# CITY OF ALBUQUERQUE

November 7, 2005

**Re: Wong Market, 129 Pennsylvania NE - Traffic Circulation Layout  
Architect's Stamp dated 10-20-05 (K19-D132)**

1 A1 TRAFFIC CIRCULATION LAYOUT

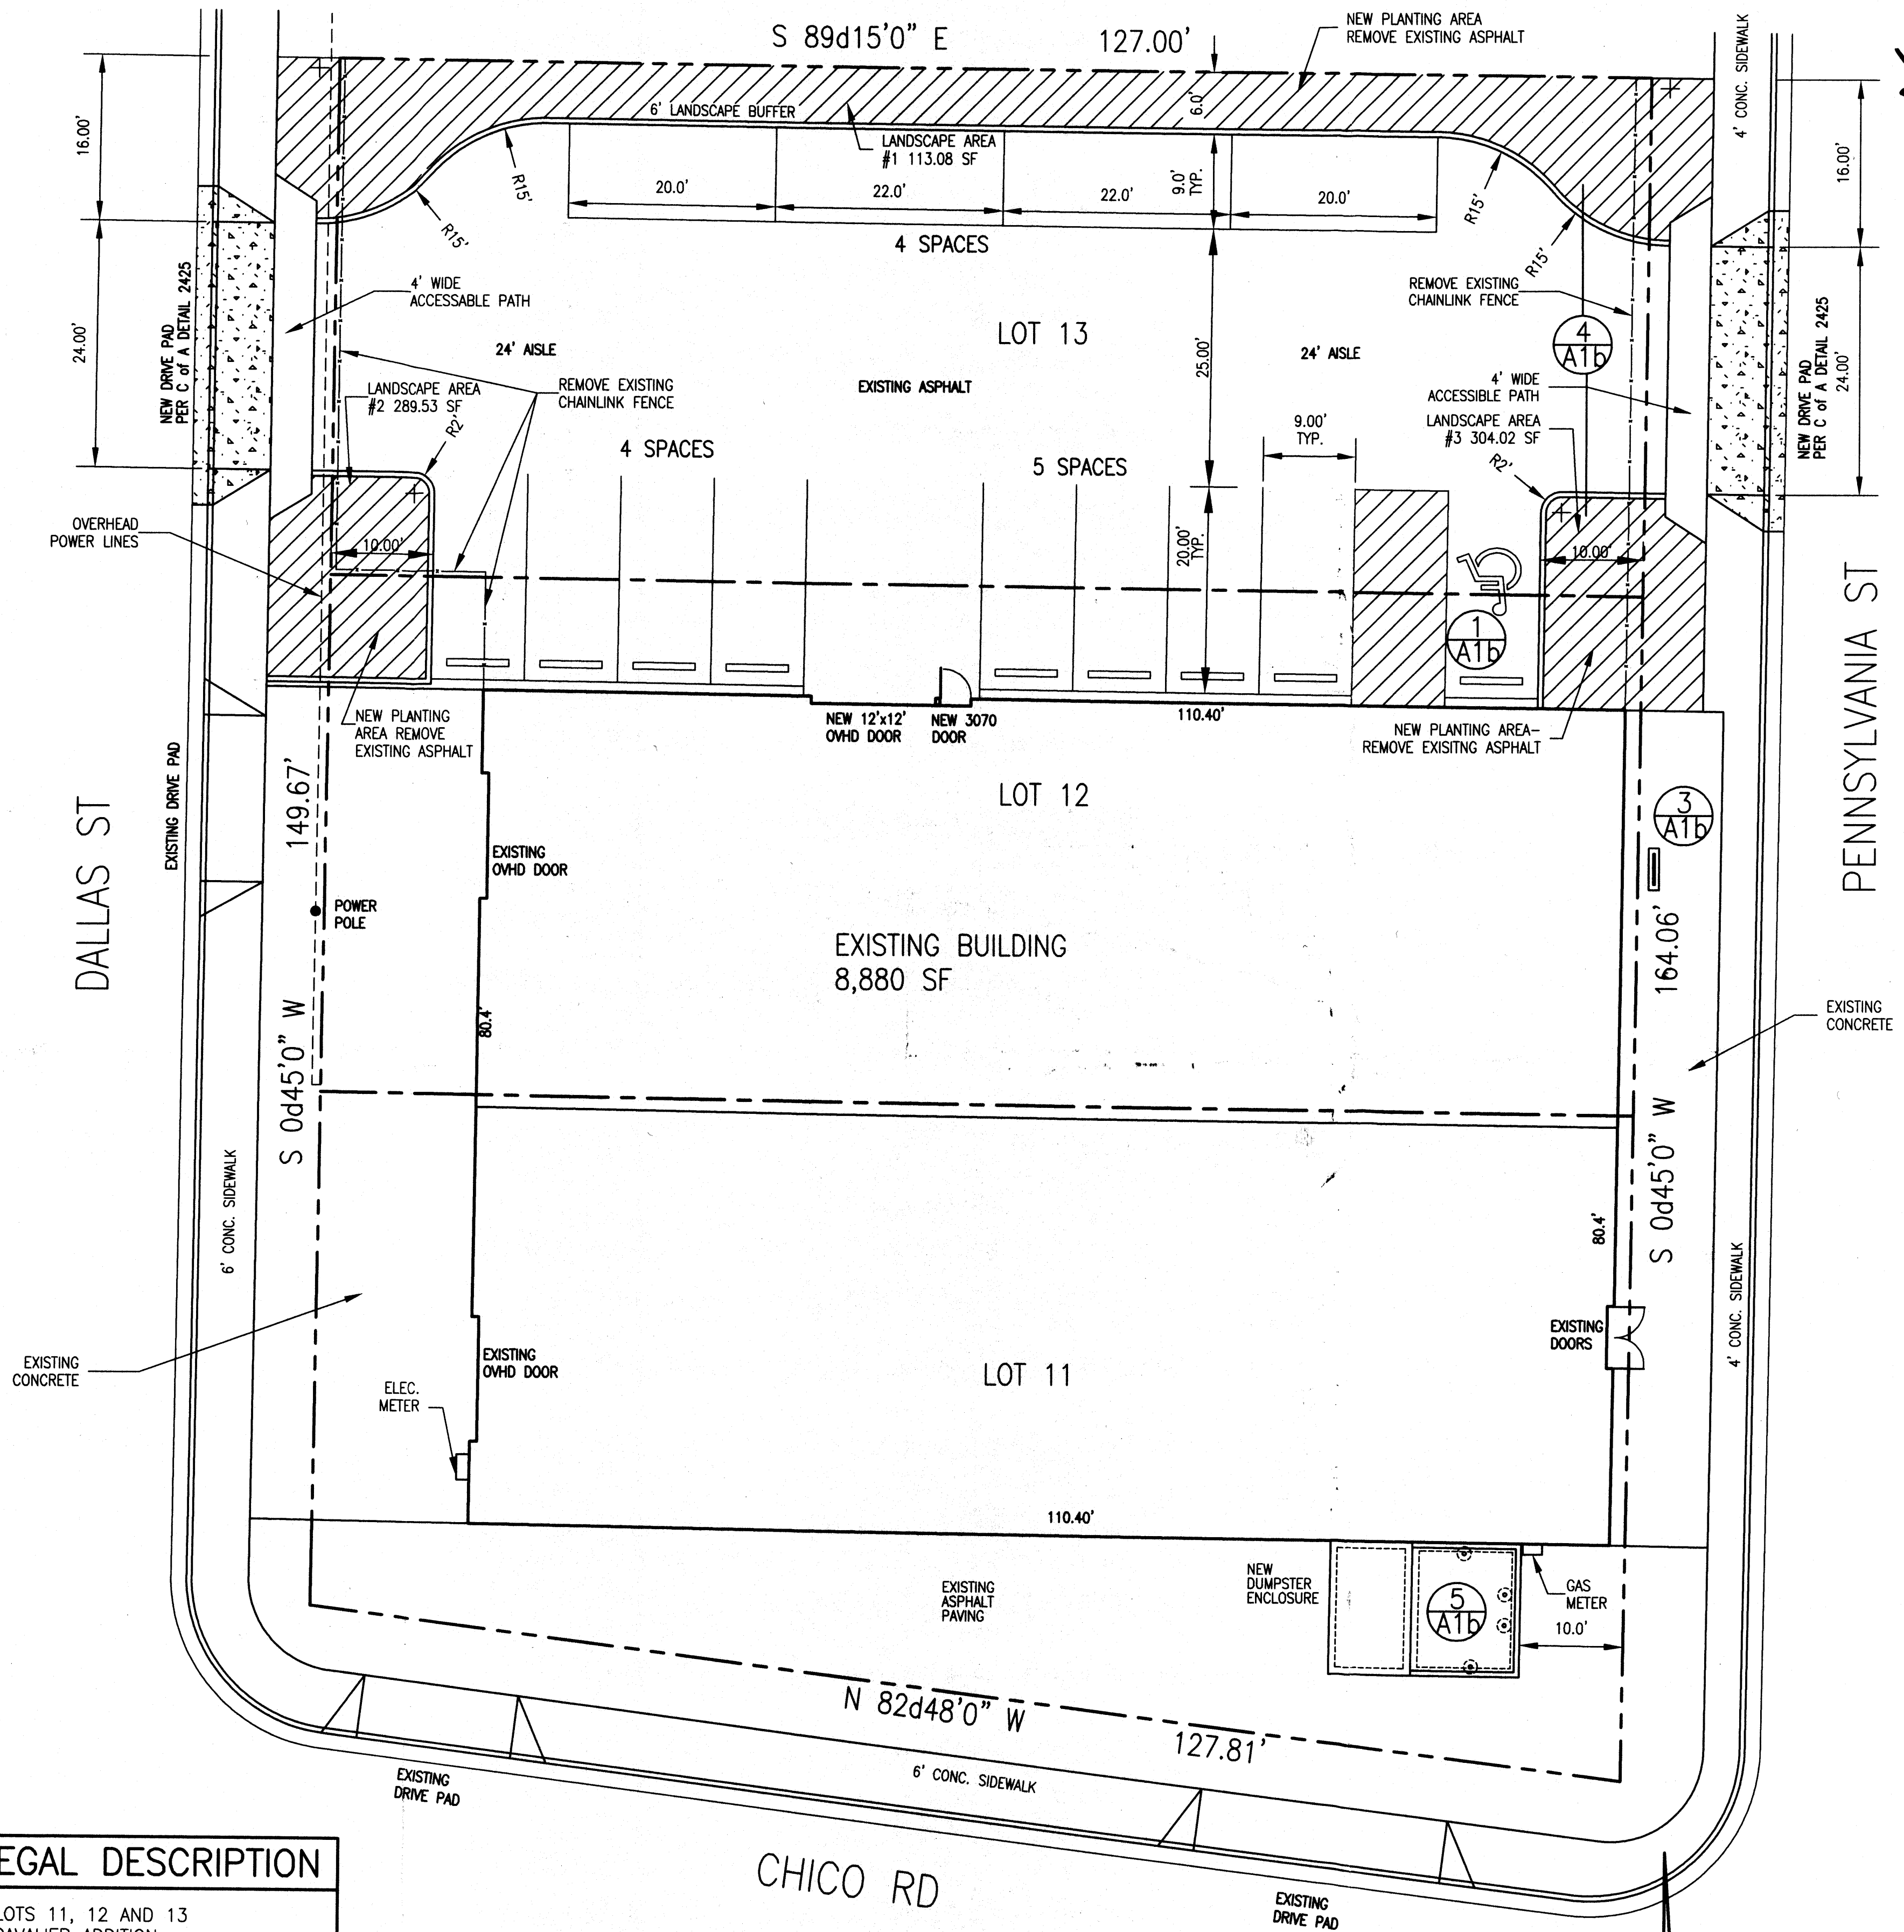
- Are their existing ADA ramps at corners of Pennsylvania/Chico and Dallas/Chico?
- Is a sidewalk required along the north side of the existing building?
- Can drive pads along Chico be closed?

- The drive pads along Chico cannot be closed due to the access to the dumpster by Solid Waste.
- Currently, there are not ADA ramps on the corners of Pennsylvania/Chico and Dallas/Chico. A new detail has been added to accommodate this requirement.
- We resolved Zoning requirements with Mathew Conrad from the Zoning department. If there are questions regarding these requirements, please contact Mr. Conrad at 924-3850.
